From: Martyn White
Sent: 28 August 2019 16:35
To: Planning.Responses <Planning.Responses@arun.gov.uk>
Cc: Richard Castro-Parker <Richard.Castro-Parker@arun.gov.uk>
Subject: EP/179/18/PL

EP/179/18/PL

I note that further revised plans are provided on this application which have removed the second-floor accommodation. This results in the dormers being removed from the elevations.

Project: Proposed new homes; Gladwyn, The Street, East Preston BN16 1HT			
Drawing: Block plan, bin store elevations			
For: Mrs. J. Simmonds & Mr. P. Beamish			
Drawn: PKS		Date: November 2018	
Scales: 1:50 1:200		No: 2386/01/03/C	
To scale when printed on A3

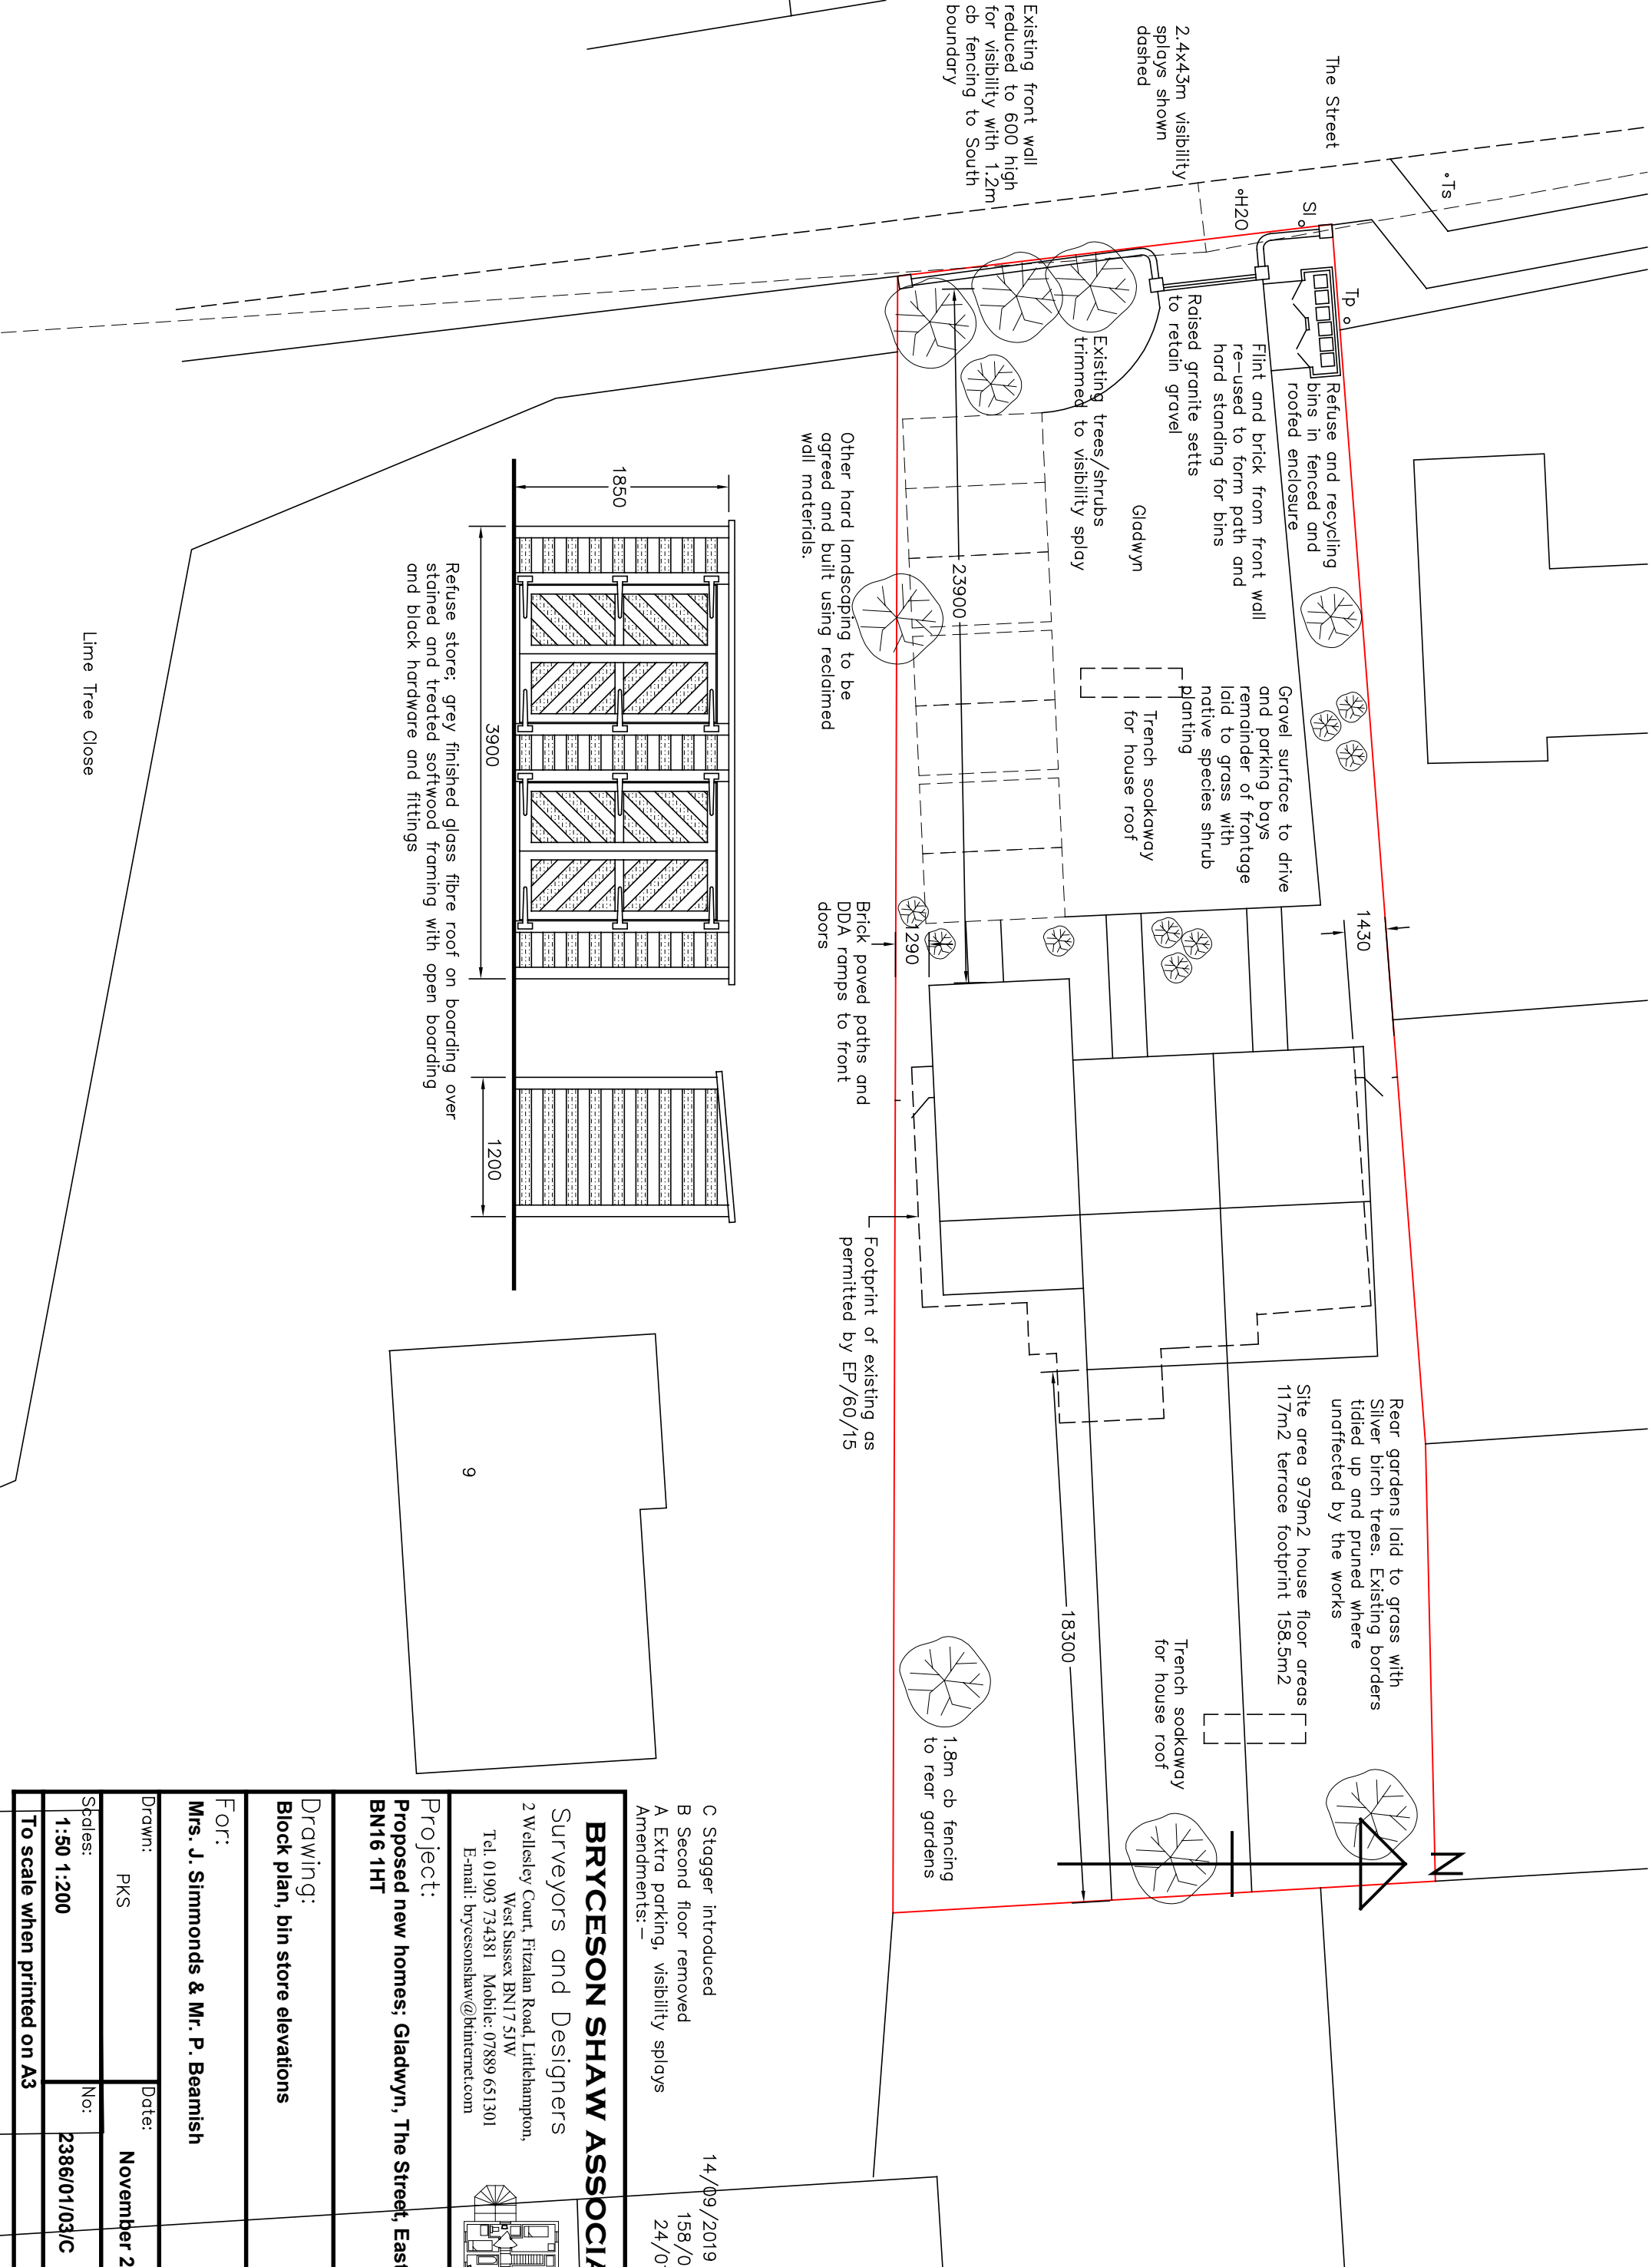
Further information is also provided with regards to the proposed landscaping on the block plan. This includes reference to 'other hard landscaping to be agreed and built using reclaimed wall materials'. You may wish to request details of this by way of condition?
